Application no: 23/01132/DISC

Location: Oxford Technology Park, Technology Drive, Kidlington, OX5 1GN

Transport Development Control

Condition 9: Objection

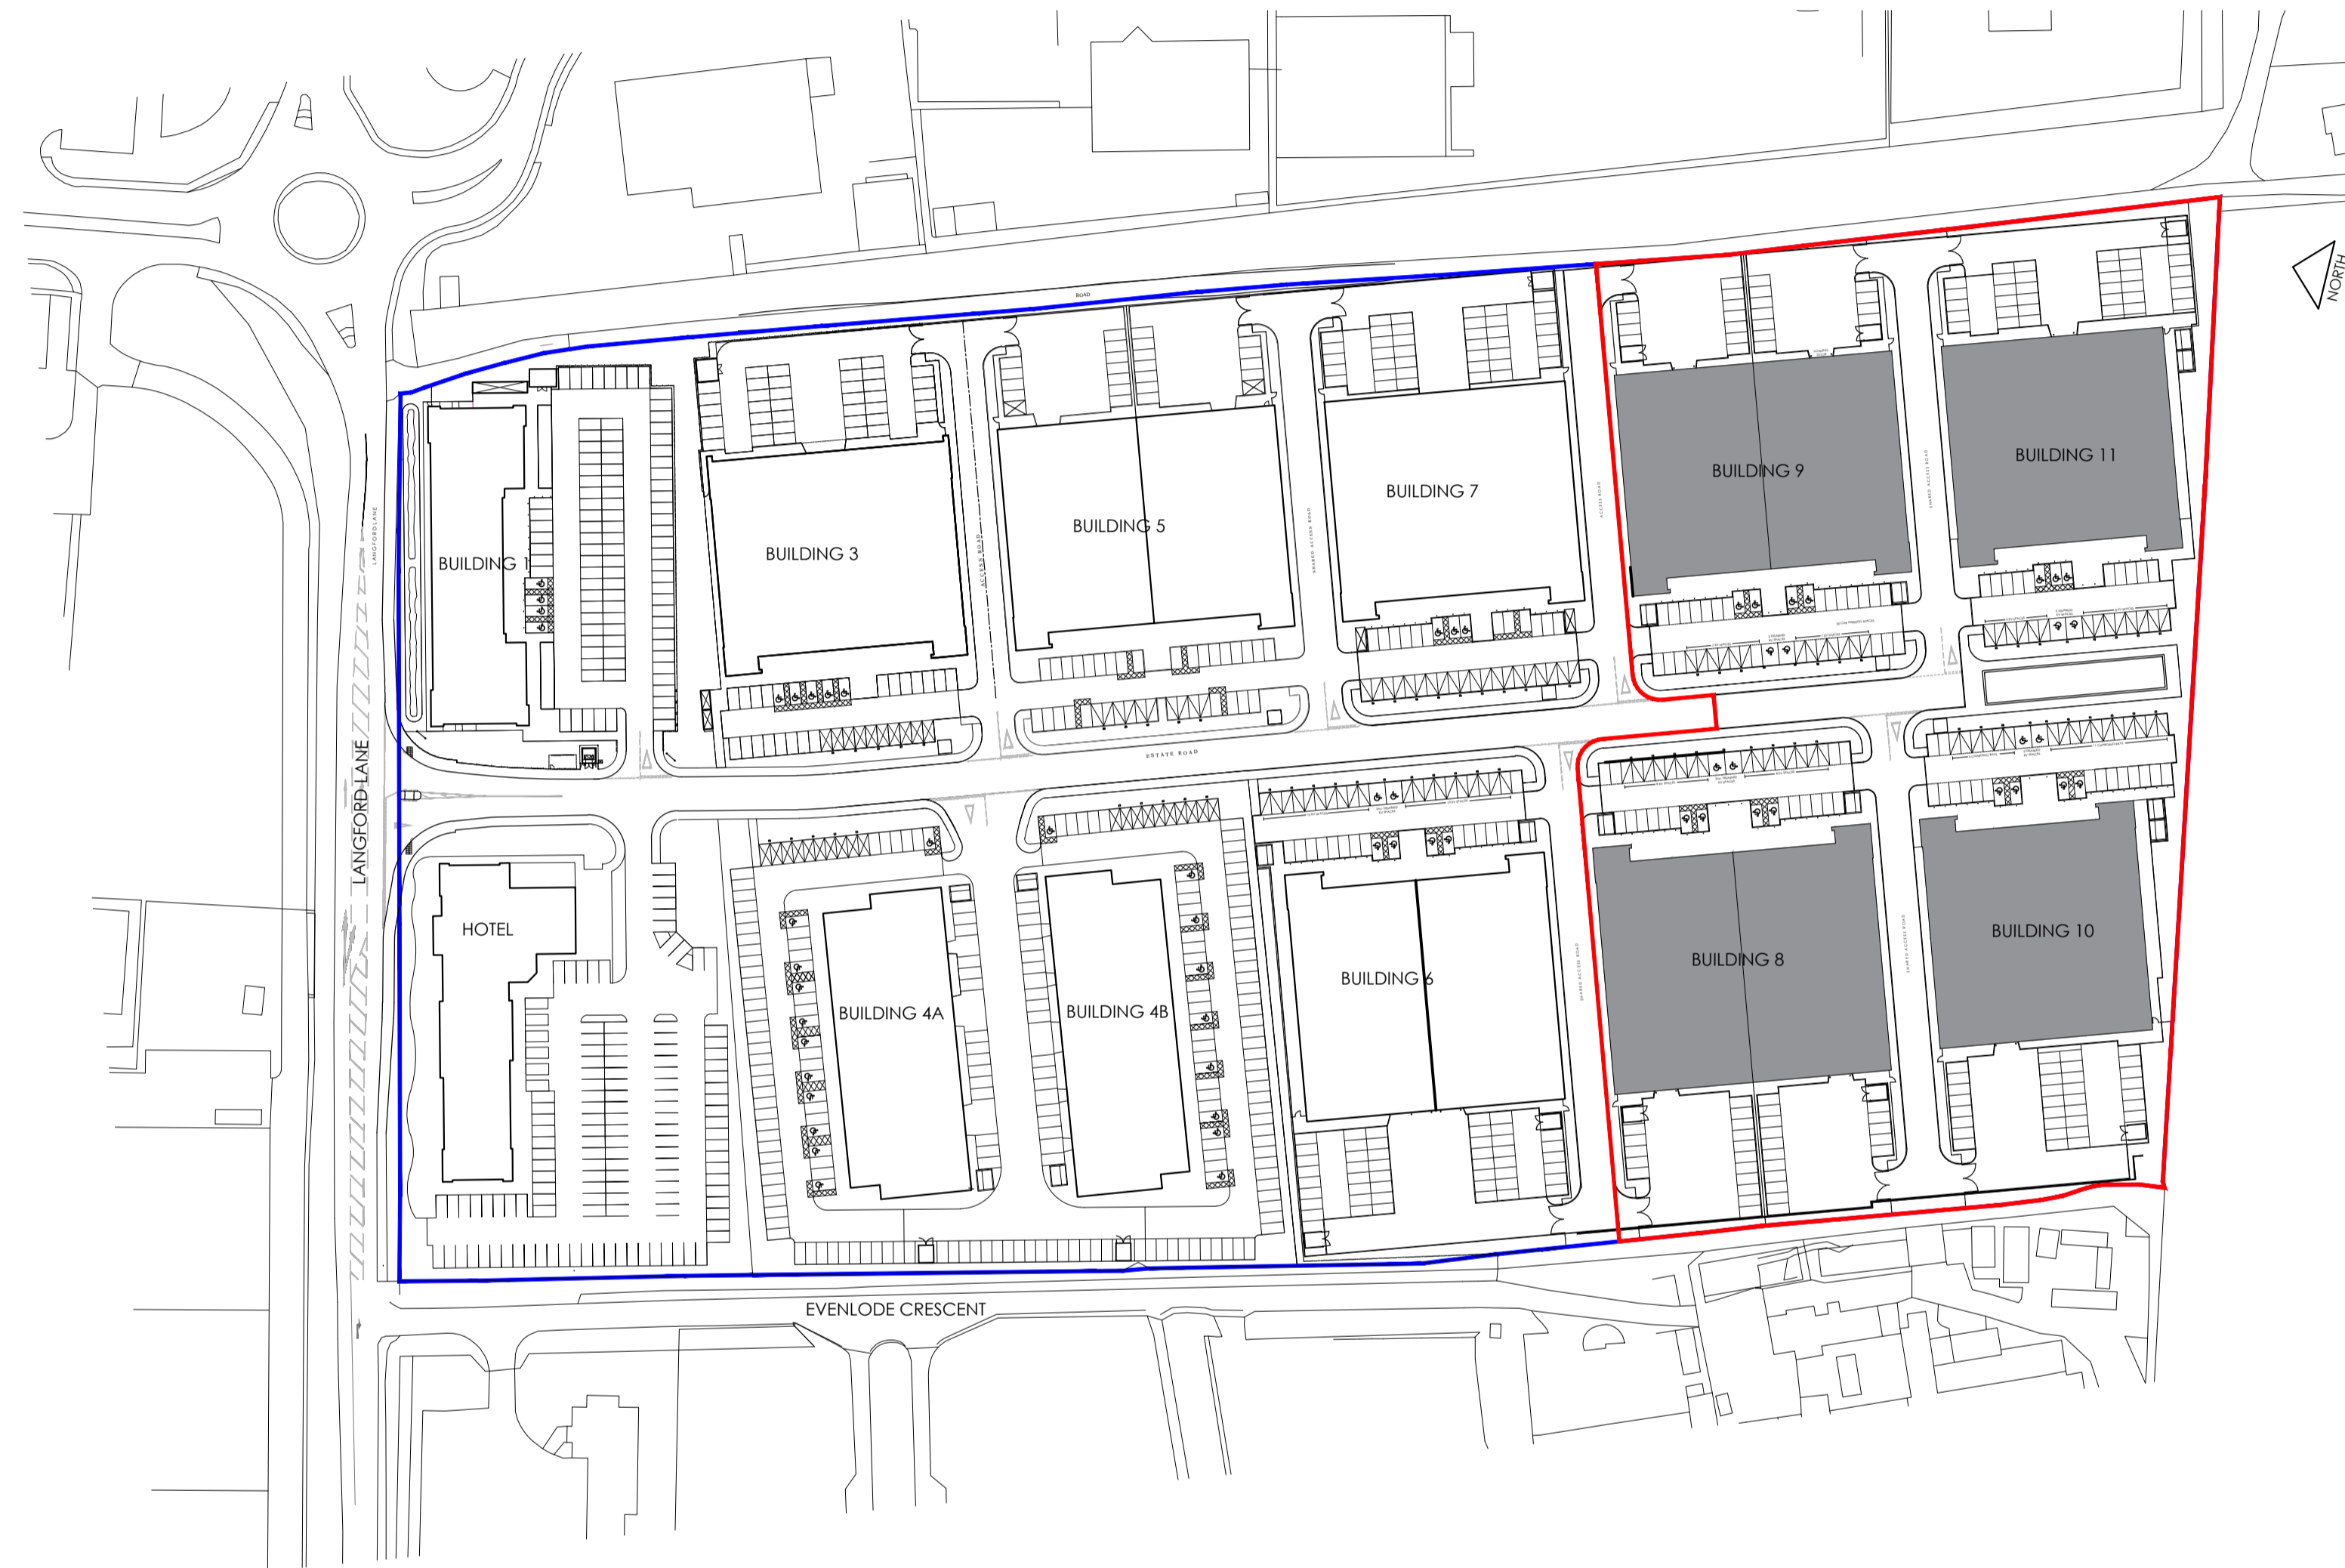
- What is the planned/ estimated date of occupation? From looking at the website it seems that the hotel may already be operating?
- The inclusion of a site plan is required.

Site Layout
 Scale 1:500

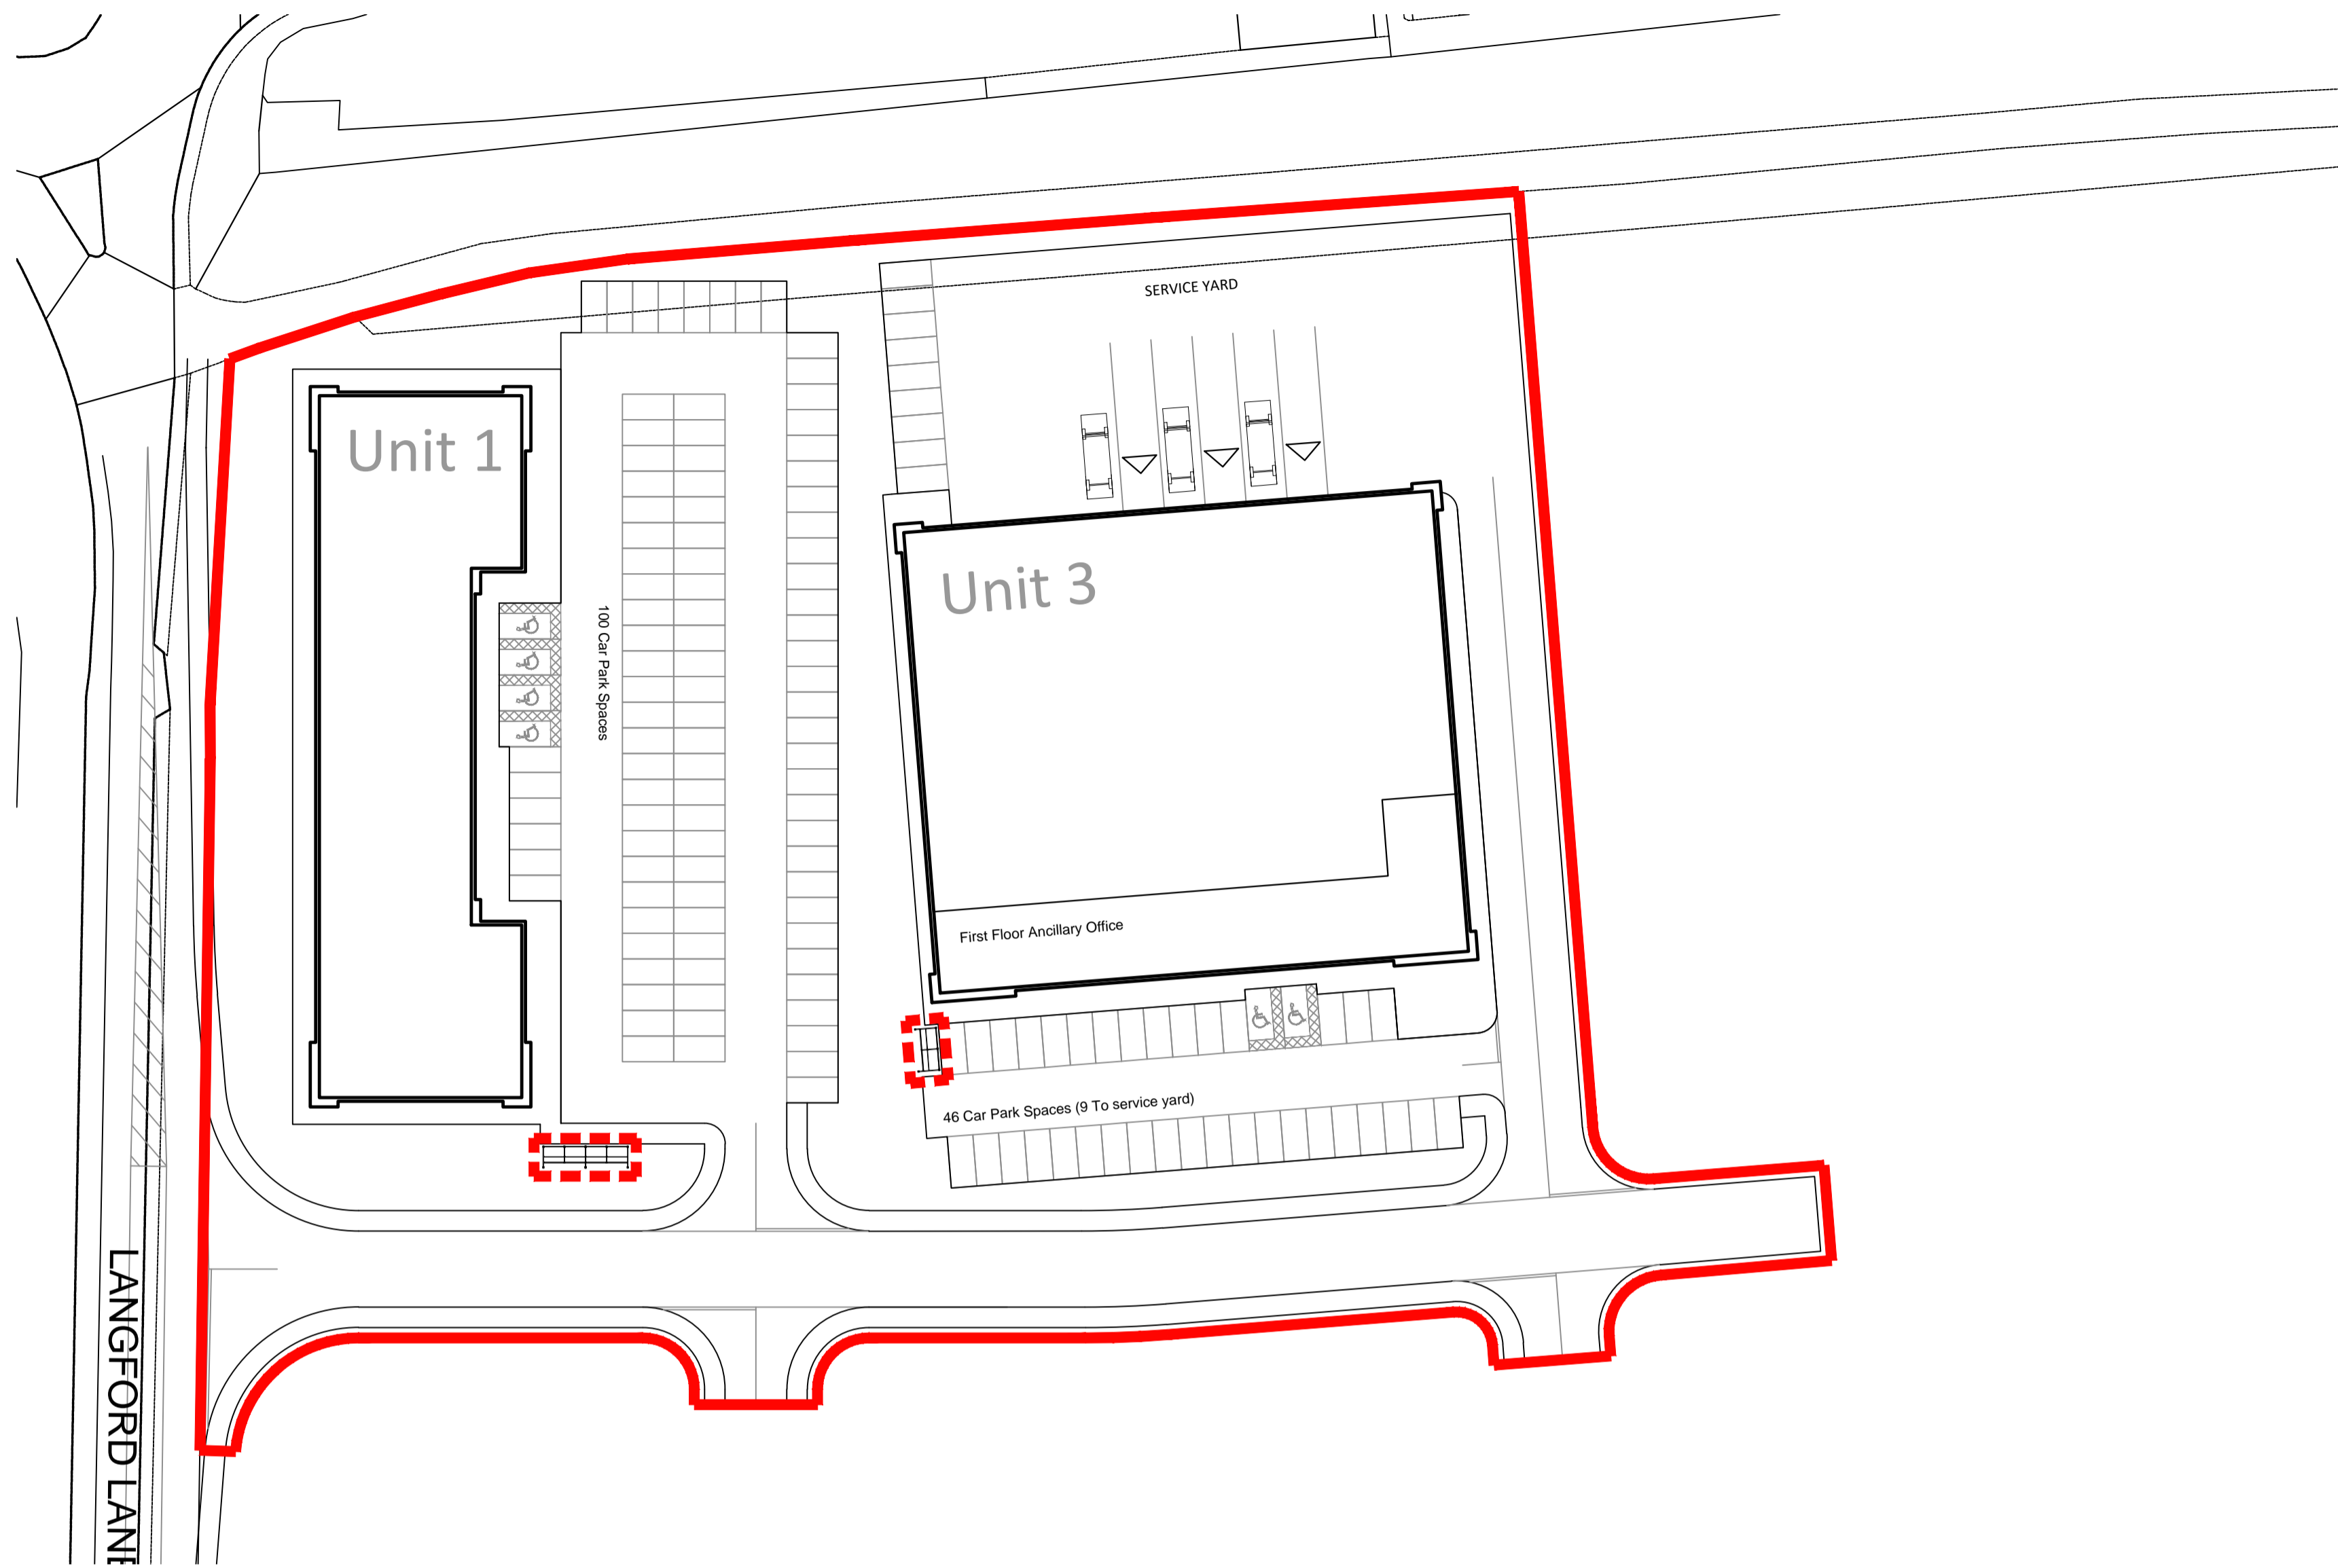
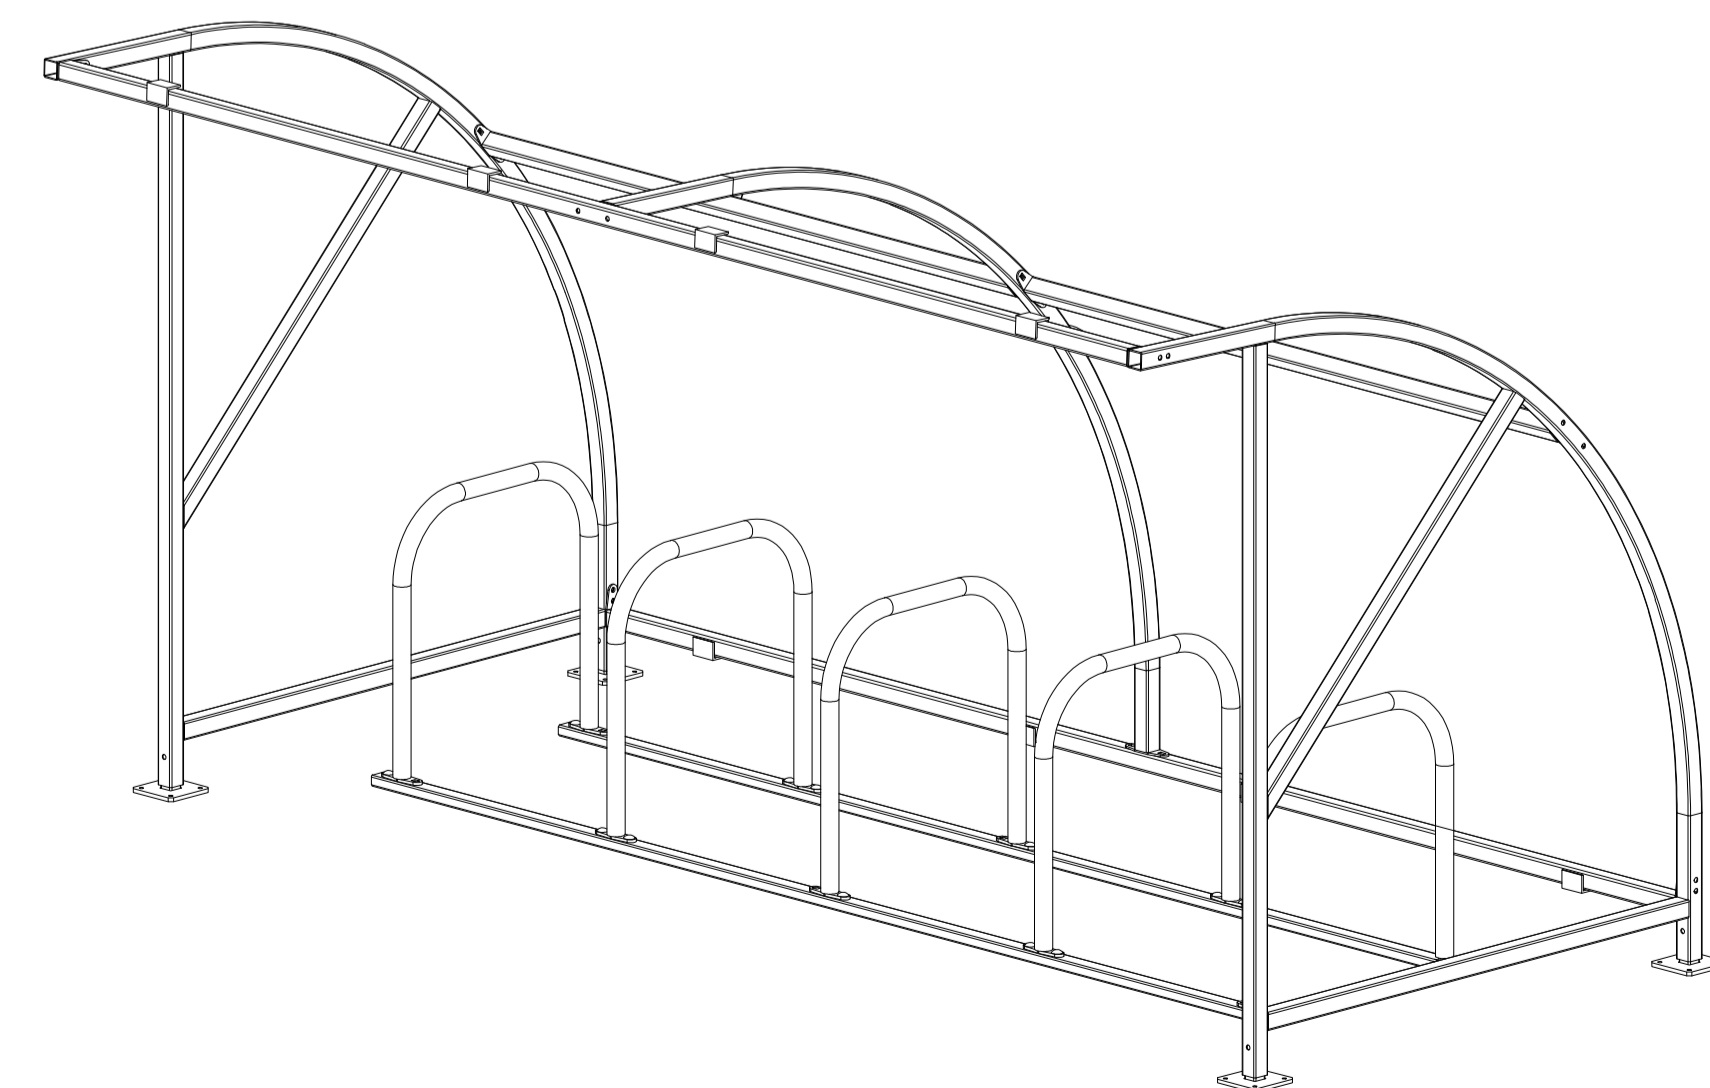
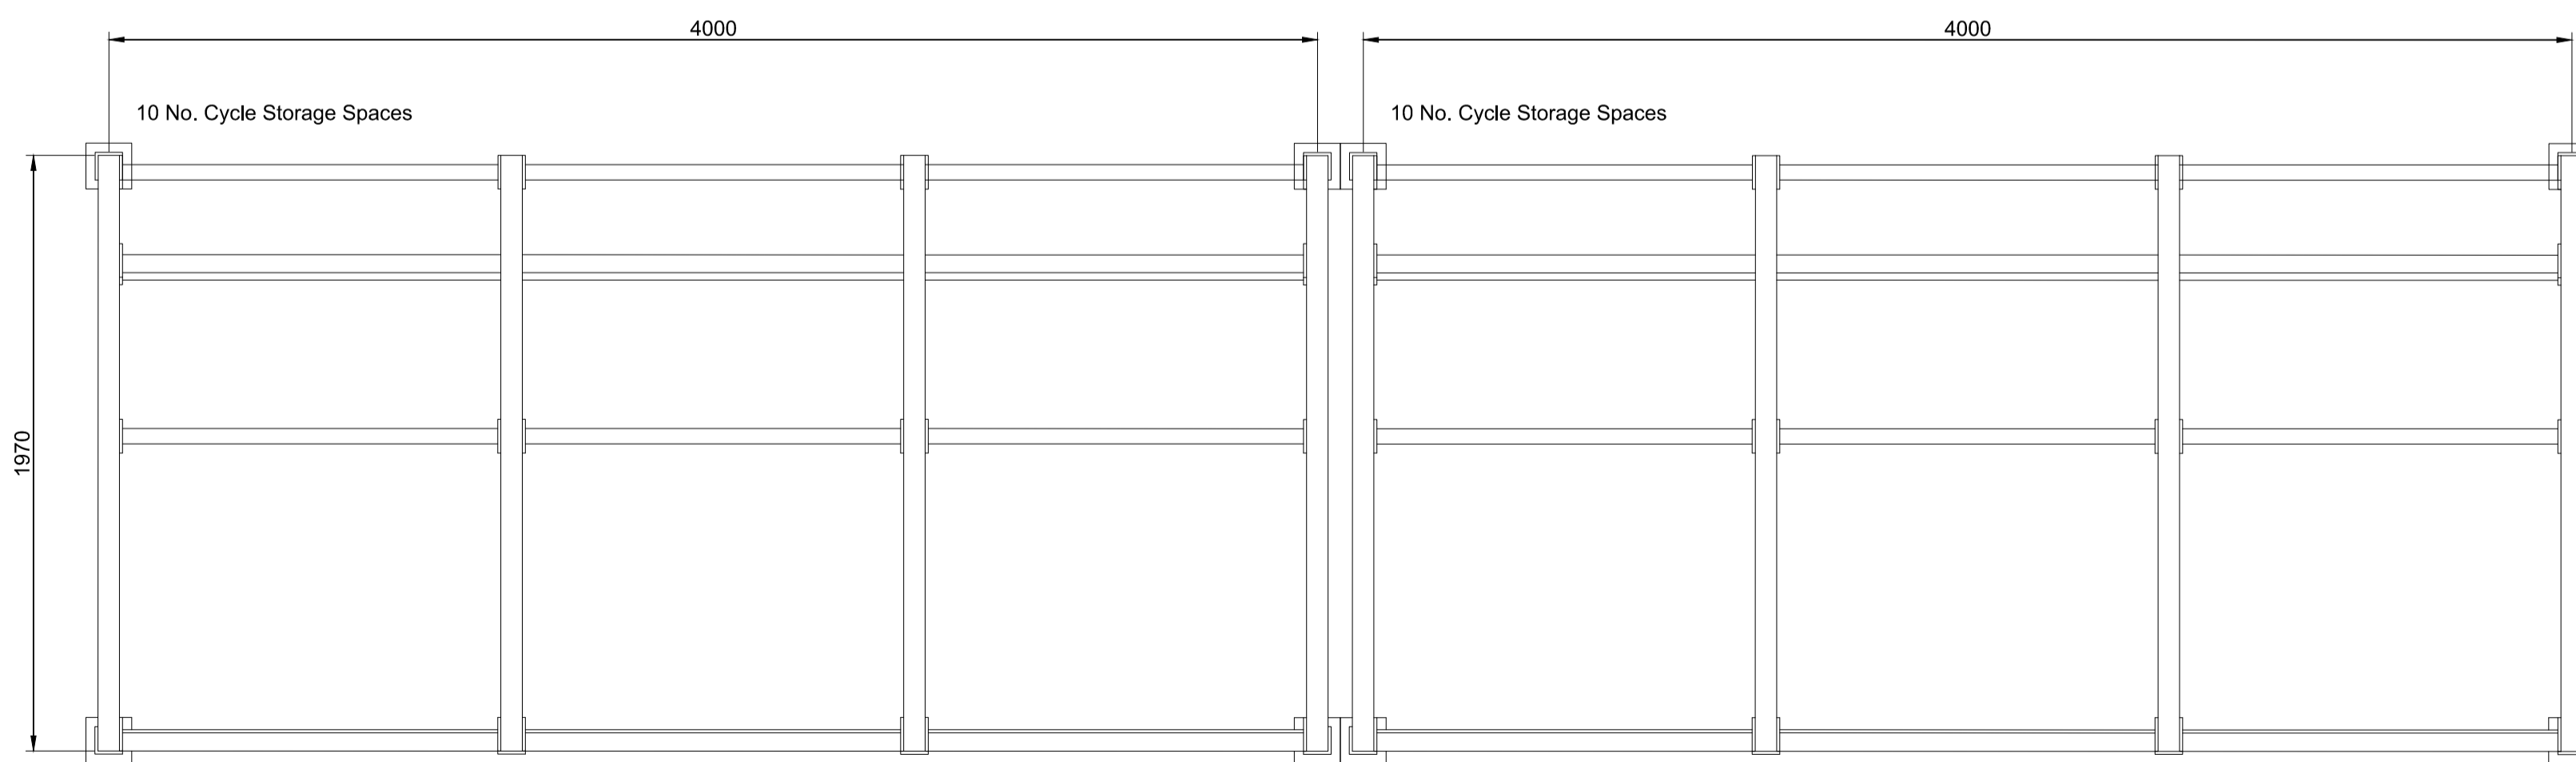
- Further information about the onsite facilities for pedestrians, cyclists and vehicle users should be included. For example – Are there pedestrian facilities throughout the site – crossing points, lighting, dropped kerbs etc. How many cycle parking spaces will be provided? Will these be covered? Secure? How many car parking spaces will be provided? Will there be any designated car sharing spaces?
